I am writing to formally raise significant concerns regarding the proposed 13-storey housing development at 25–27 Boyd Street, Tweed Heads (25-27 Boyd Street, Tweed Heads Affordable Housing), as detailed in the submission documents prepared by Homes NSW and its associated consultants. After thoroughly reviewing the Traffic Impact Assessment (TIA) by Cathy Thoms and Sean Morgan (Ver04, Reference: P2559, 28 November 2024), the Social Impact Assessment (Final Report, 28 November 2024), Appendix G (cost and procurement details), the Environmental Impact Statement (EIS), the Accessibility and Arborist Reports, the Landscape and Public Domain Plan, the Design Report, the Architectural Drawings, and other relevant documentation, I have identified numerous critical issues that require immediate attention and response.

## **2. Traffic and Road Network Capacity Constraints (Reference: TIA, Ver04, P2559, 28 November 2024)**

DA Package

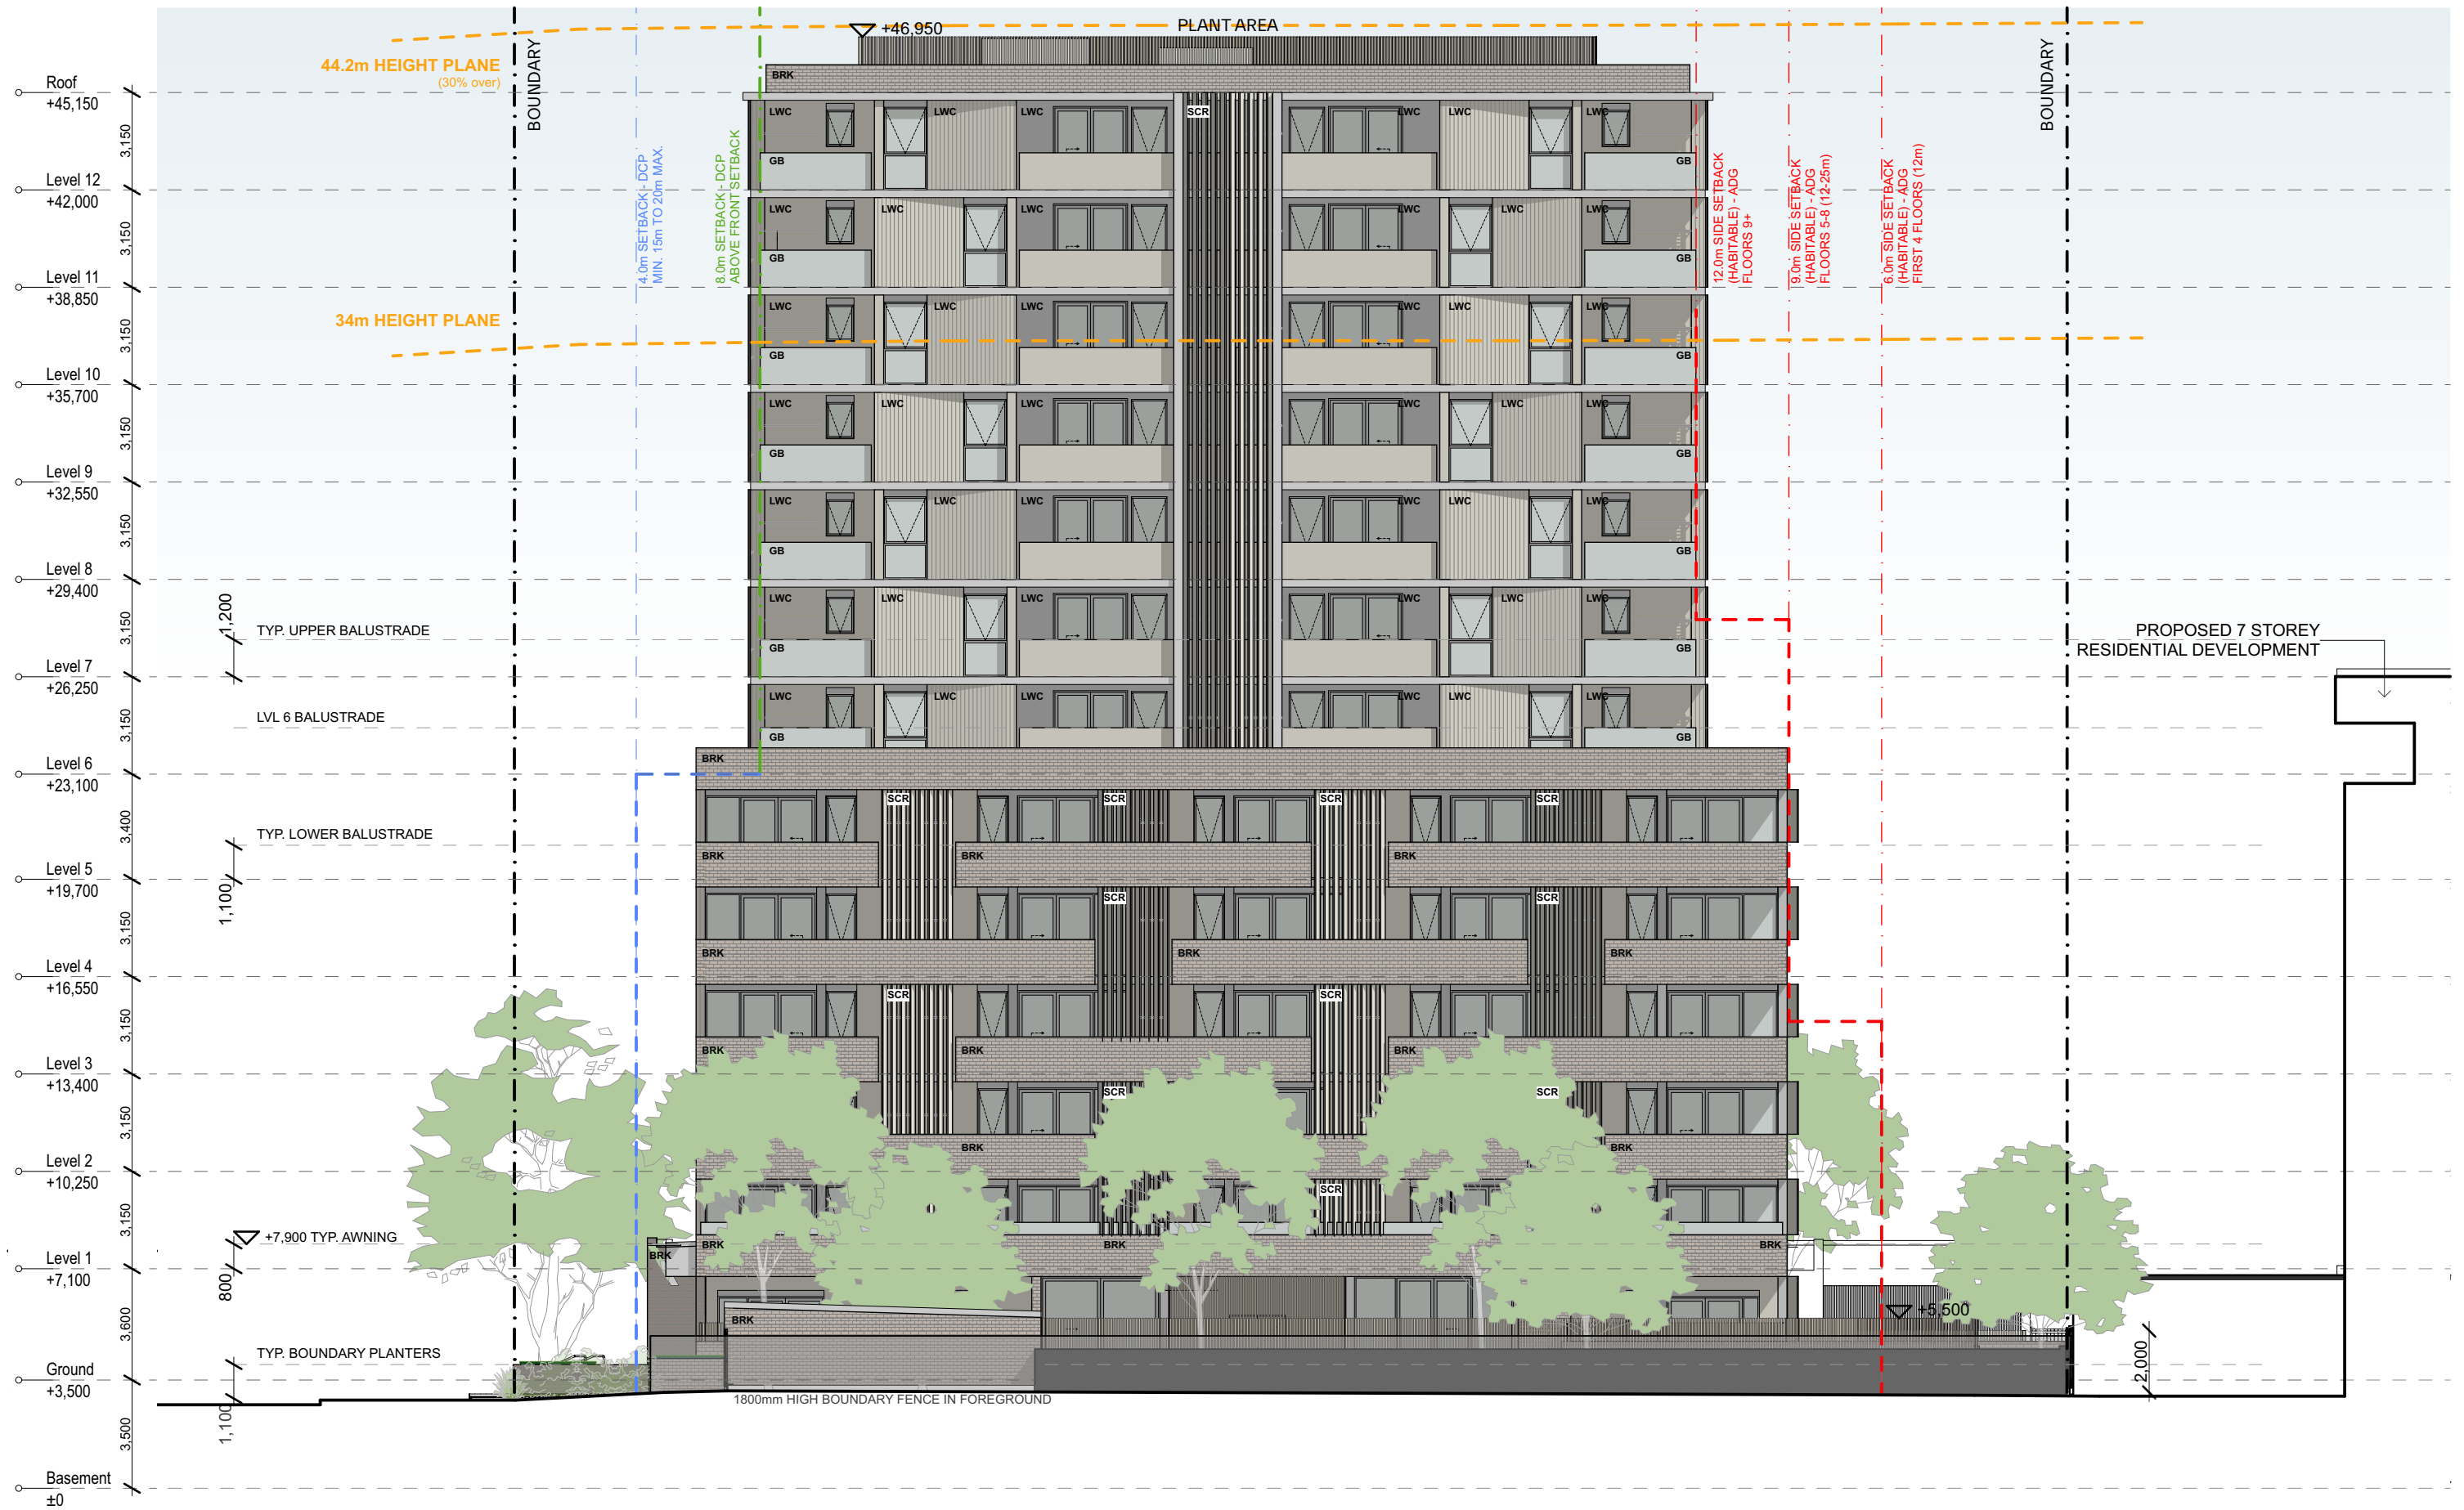
This development is grossly out of scale with its surroundings. The tallest building currently within sight of the proposed development is seven storeys. There is no precedent for a 13-storey structure in this precinct.

- Neighbourhood Character Impacts: A 13-storey tower in a low-to-medium-rise area significantly alters the character and amenity of the neighbourhood, a factor not sufficiently assessed within the submission.

LEP
BUILDING ENVELOPE SHADOW DIAGRAMS

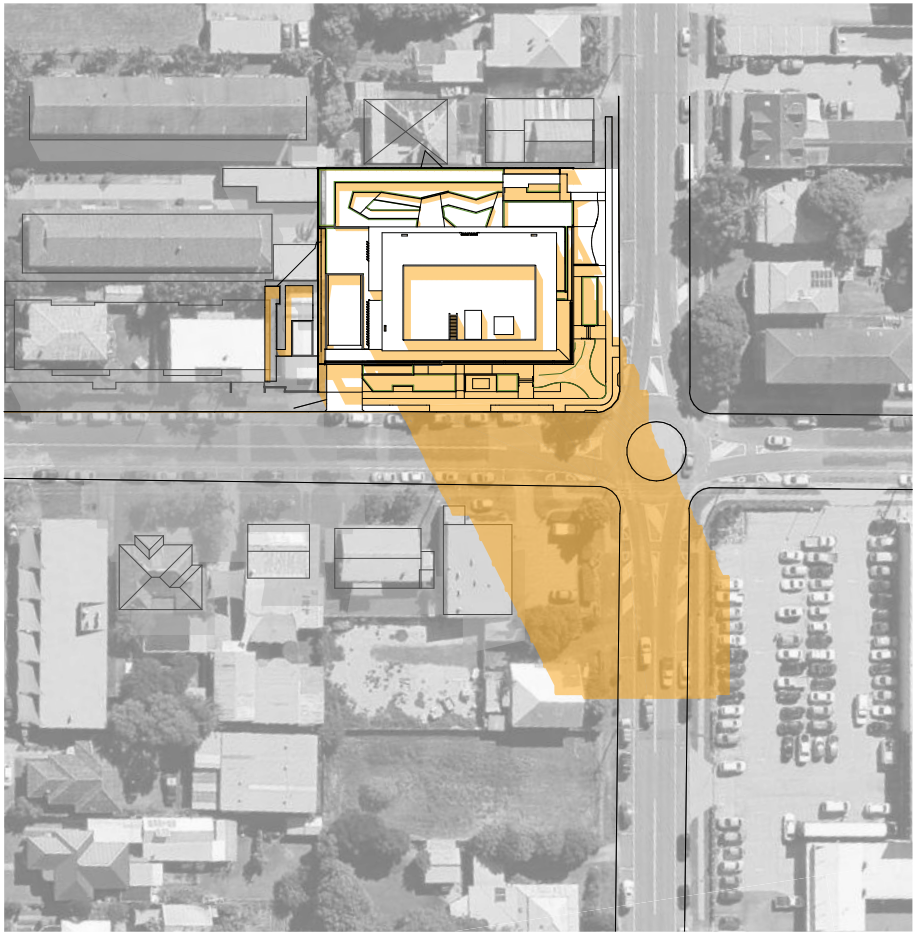
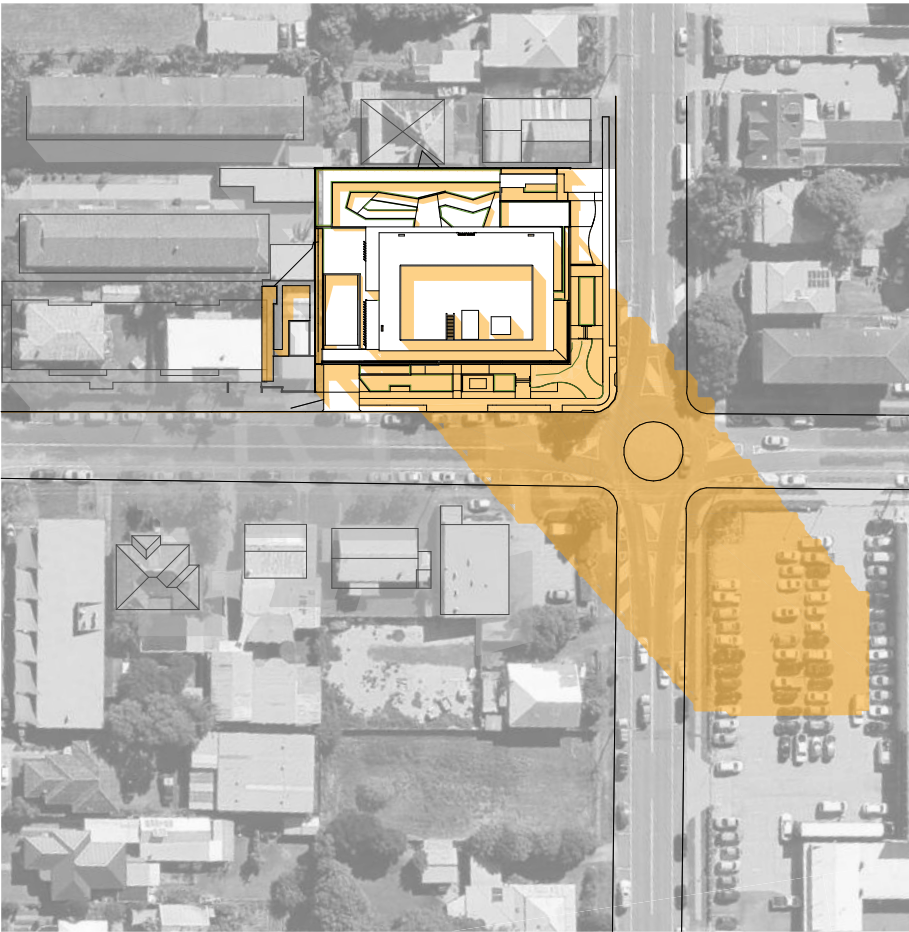
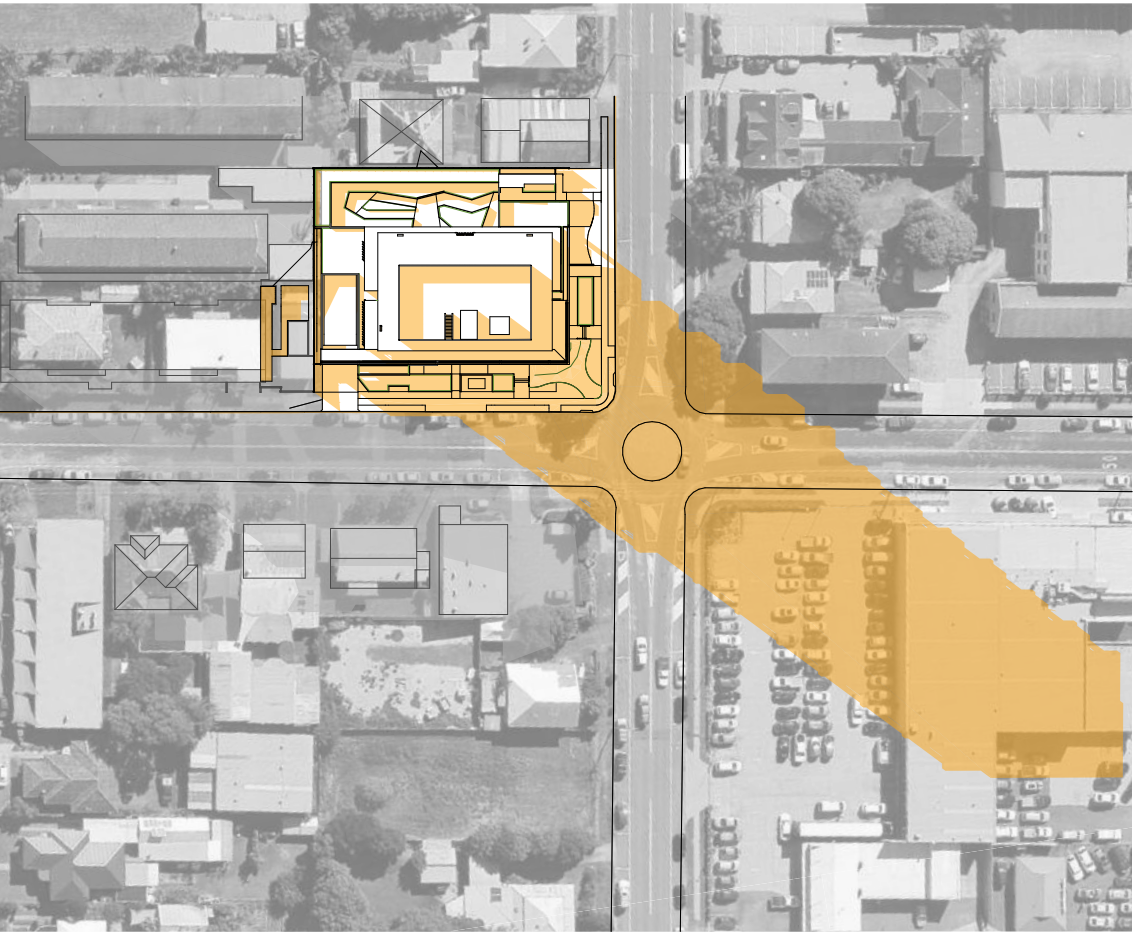
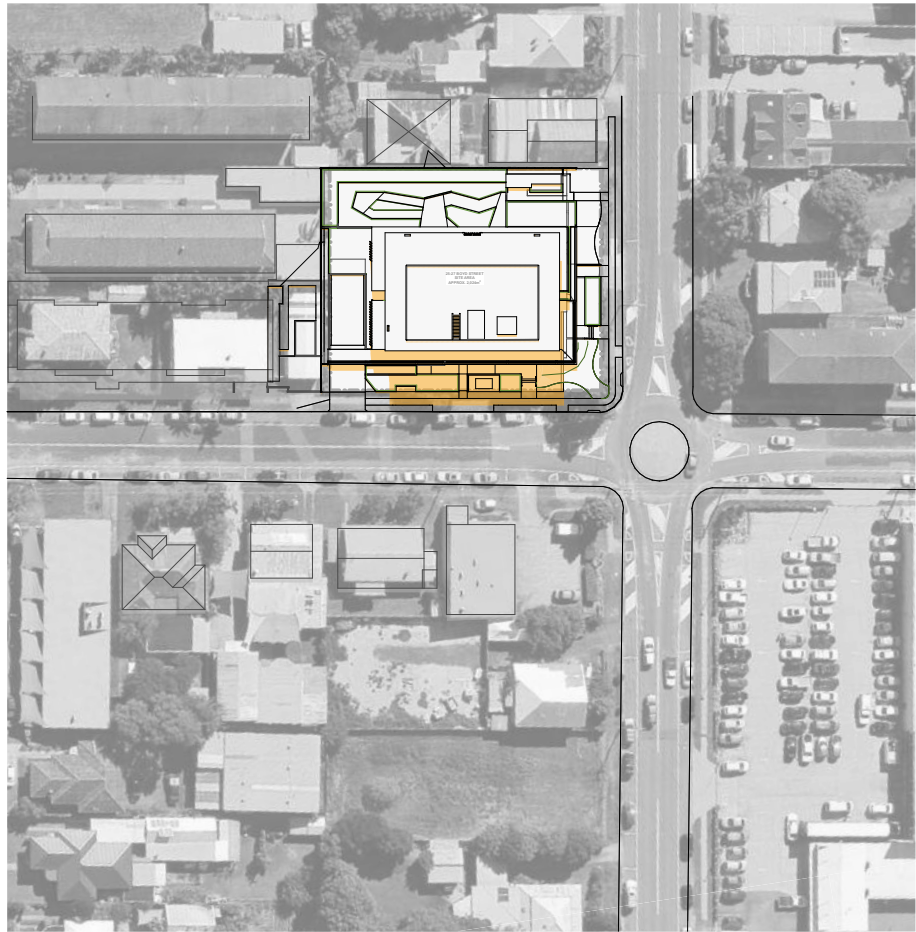
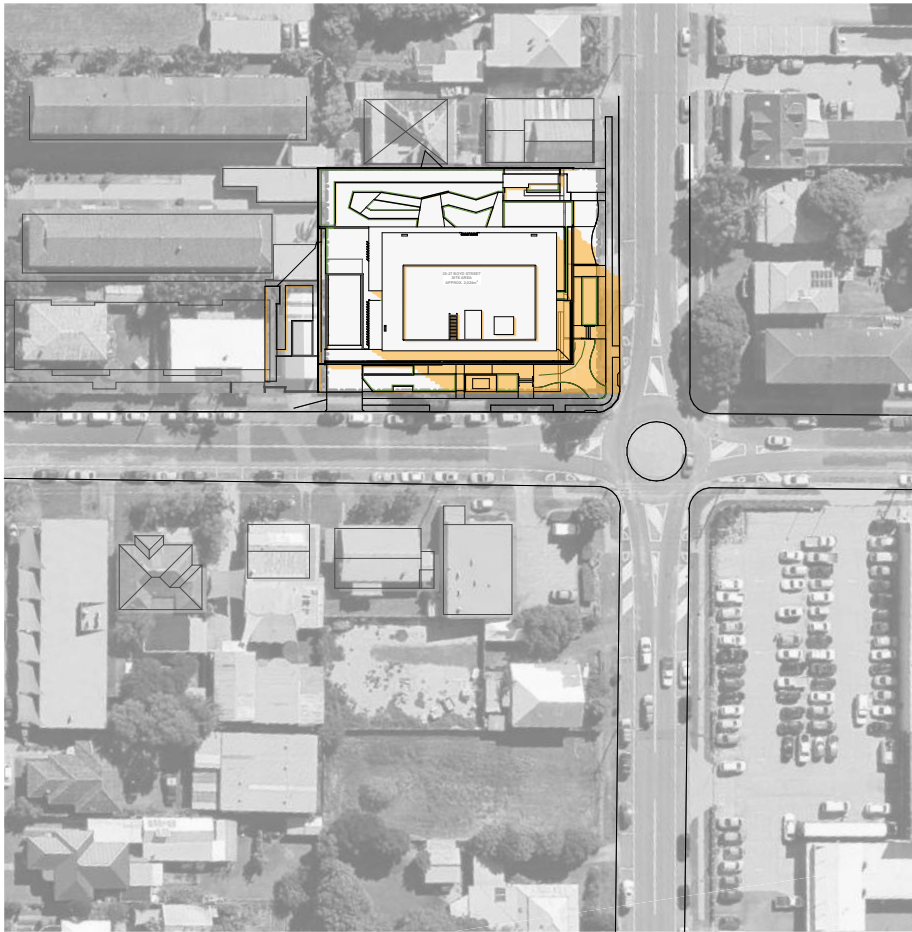
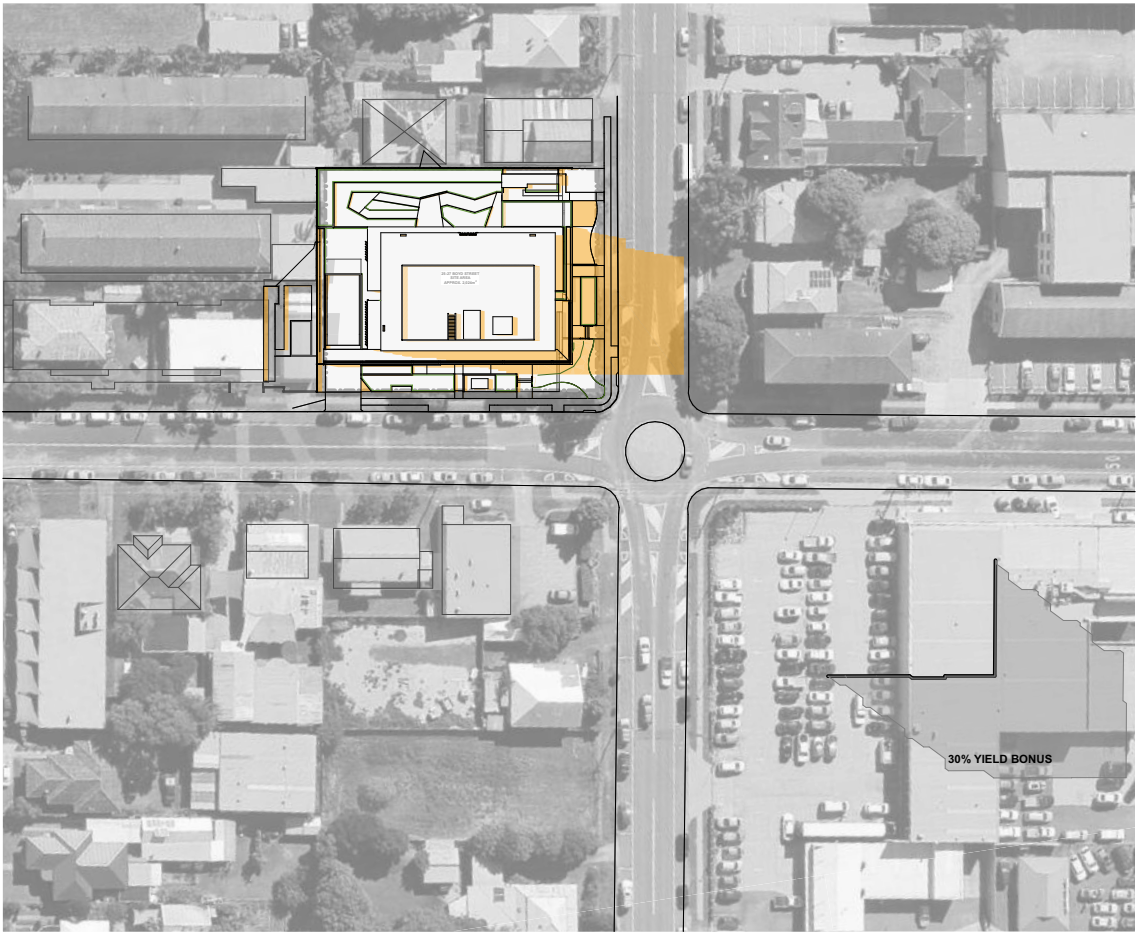
There is no detailed shadow analysis for the proposed 13-storey structure. Preliminary calculations suggest that:

- Summer shadow lengths could exceed 42m, impacting surrounding residences and communal spaces.
- Winter shadow lengths could reach 90m, significantly reducing amenity and sunlight access for adjacent properties.

A **comprehensive shadow modelling report** should be submitted immediately.
